RE: Lot 2 Elm Grove Villa - Smith Plumbing & Heating; Water Quality Detention Pond Certification

Lot 2 Elm Grove Villa  
Water Quality Detention Pond Certification  
April 8, 2024

ORFICE PLATE DETAIL
 NOT TO SCALE

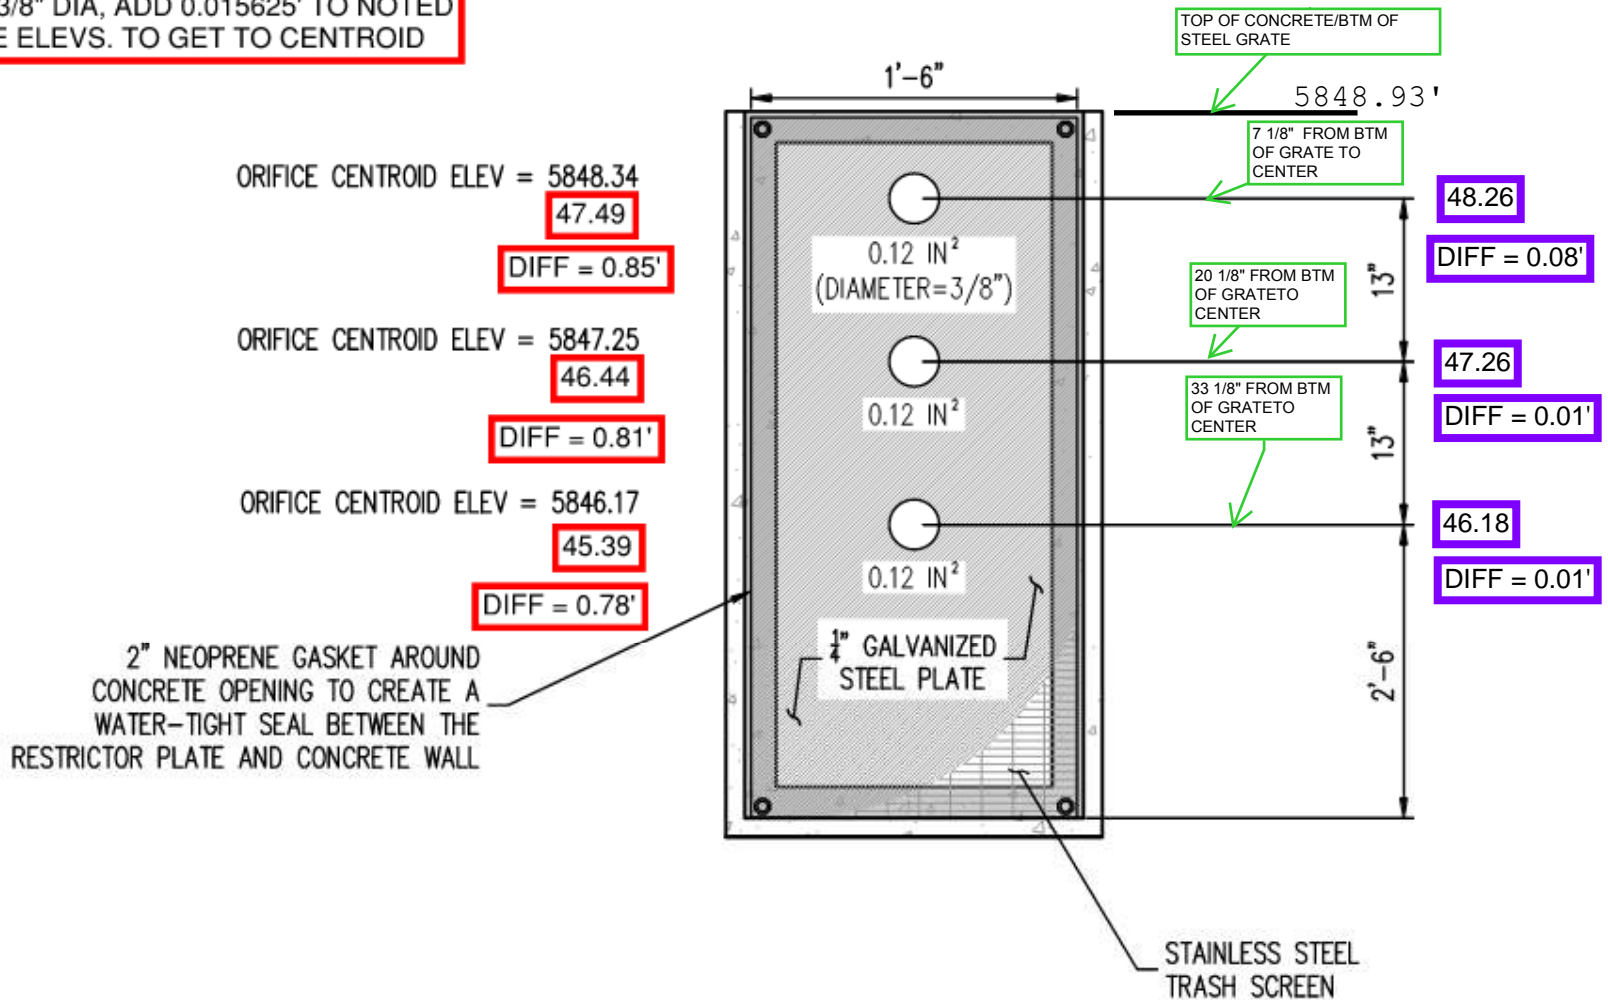
To avoid confusion, label the date that this survey data is from to clarify that the blue data is more recent - to show that the plate was modified since this red data was taken.

Or better yet, just delete all of this red data since it is not representative of the as-built condition.

Please copy all of these green and blue text boxes over to the detail on the previous page or overlay a screenshot of this page on top of the same detail on the previous page.

REVISED

REVISED AS THIS SHEET NO LONGER APPEARS IN THE AS-BUILT PLAN SET.
